KIRKLEES METROPOLITAN COUNCIL INVESTMENT & REGENERATION SERVICE

DELEGATED DECISION TO DETERMINE APPLICATIONS FOR LISTED BUILDING CONSENT

Reference No:	2023/65/90573/W
Site Address:	Hill Farm, Chain Road, Slaithwaite, Huddersfield, HD7 5TZ
Description:	Listed Building Consent for installation of new window, external steps and associated external works including demolition of boundary walls
Recommending Officer:	Katie Chew

client	JAMES KEATS AND SHONA SEARSON		
project	PROPOSED GARAGE HILL FARM, CHAIN ROAD MARSDEN HD7 5TZ		
drawing	PROPOSED PLANS		
revision	notes	date	drawn
A	YARD WALLING REINSTATED	05.23	PB
scale :	1:100 AT A1	02.23	MG
project no.	drawing no.	revision	
2228	02	A

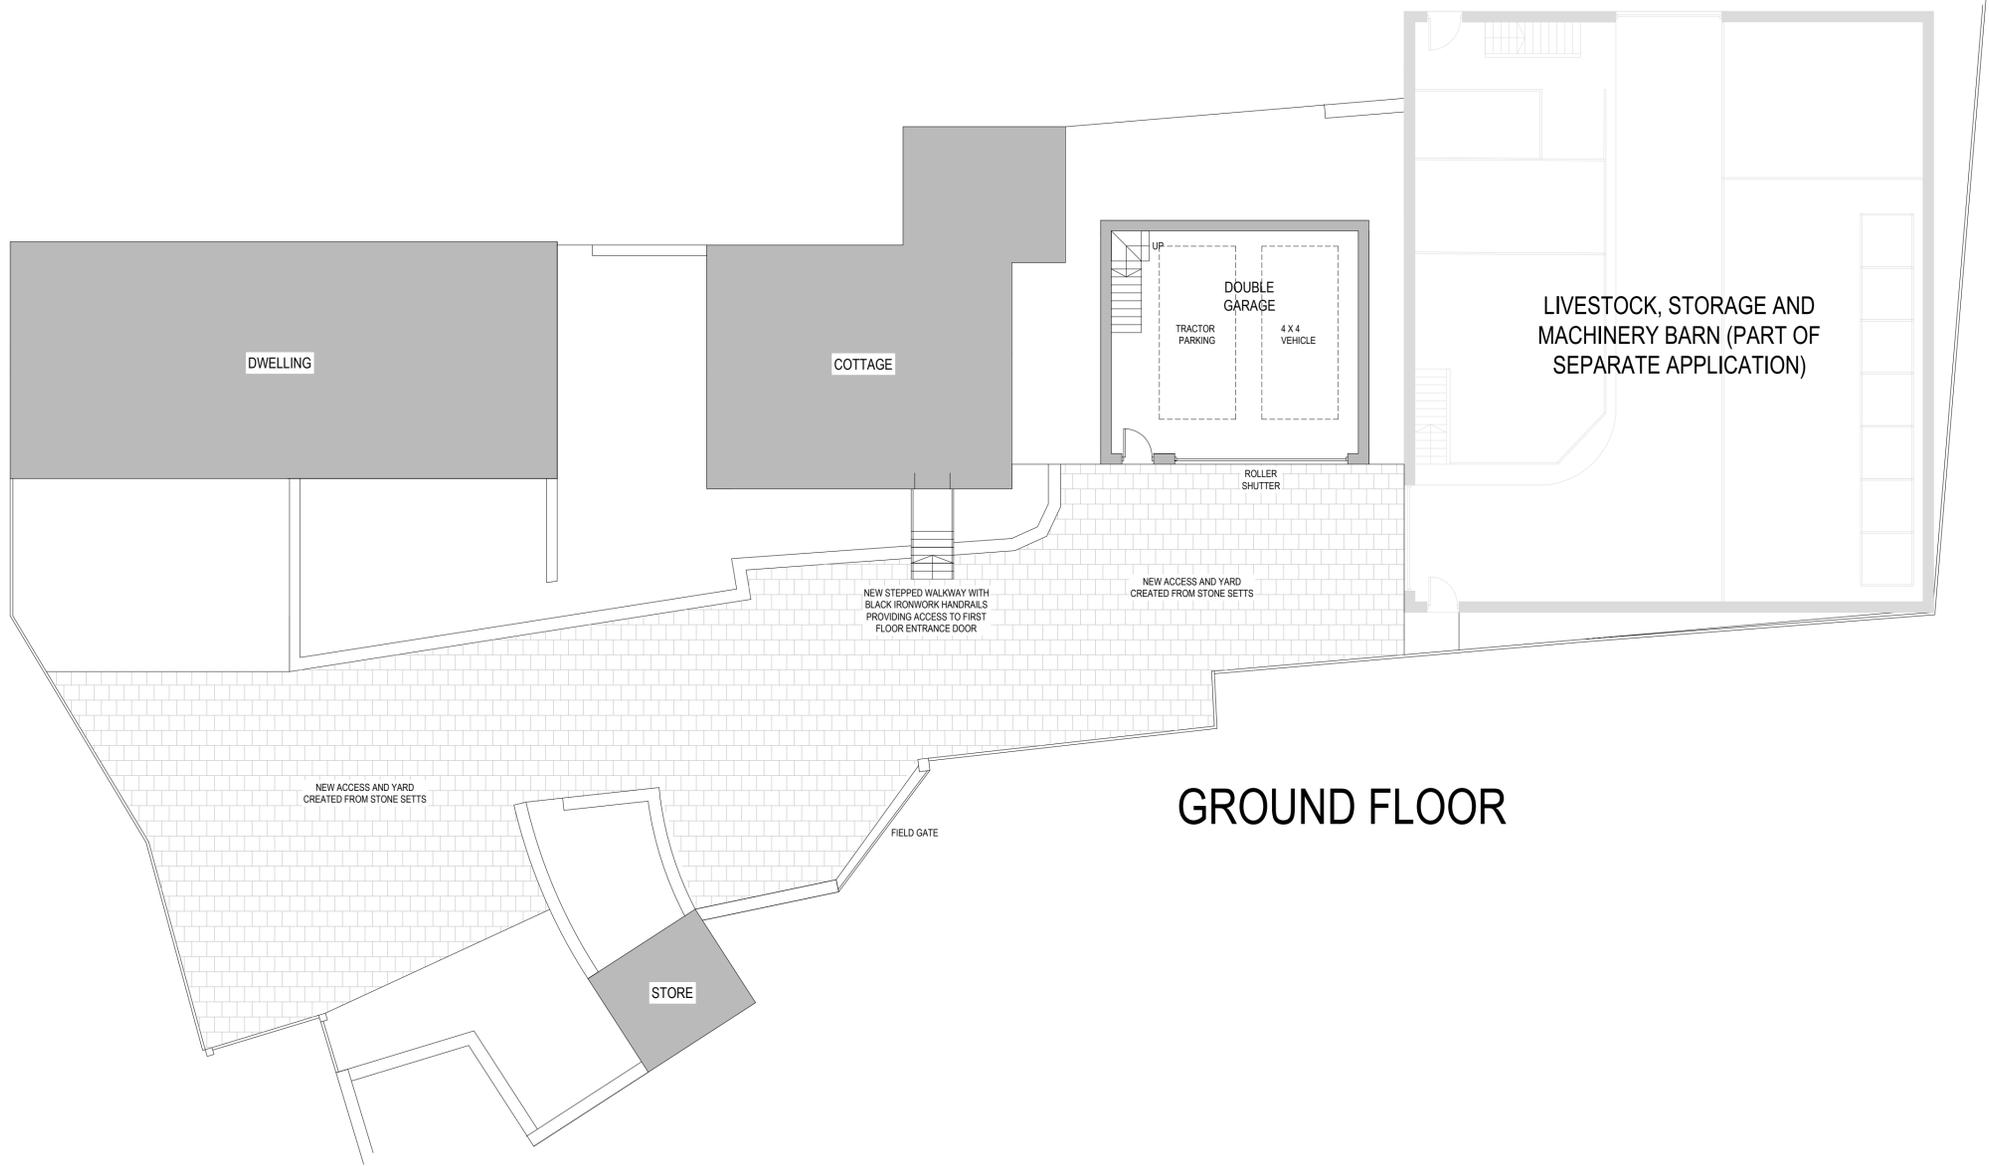
Following comments received from both Officers and the Conservation & Design (C&D) team, further details were requested to be provided in respect of the new openings and windows, stairs and handrails. It was also relayed that C&D Officers raised concerns in respect of the demolition of the garden wall along the south side of the existing access.

KC Conservation & Design – Comments received 3rd April 2023. Whilst Officers deem the introduction of external steps and the installation of new window openings to be acceptable, they do request further details to be provided on these matters. In terms of the removal of boundary walling, Officers object to this element of the scheme as the loss of boundary treatment in this location would see a substantial change to the character of the farmstead, and thus would have a harmful impact on the character and setting of the listed Cottage and The Hill.

In terms of works proposed to the boundary walls, it is outlined within the supporting plans and within the Heritage Statement that a large section of the existing drystone walls located along the south side of the existing access are to be removed. These walls form small holding pens to the detached outbuilding to the south of the site. These boundary walls are visible on historic mapping from 1854, and therefore their removal would see a substantial change to the character of the farmstead. The C&D's Officers concerns were relayed back to the applicant's agent who sought to amend plans to retain more of the yard walls, this change is welcomed by Conservation & Design.

Amended plans were received which sought to reduce the overall level of demolition of the garden wall which was welcomed by C&D Officers. No additional details were provided in respect of the windows, stairs, new openings or handrails and therefore conditions are to be imposed should planning permission be granted.

Officer note: Following receipt of amended plans which seek to retain some of the yard walls which were originally proposed to be removed. The Council's Conservation & Design Officers were re-consulted and noted that they welcomed the retention of some of the yard walls and deem the proposals in this respect to now be acceptable.
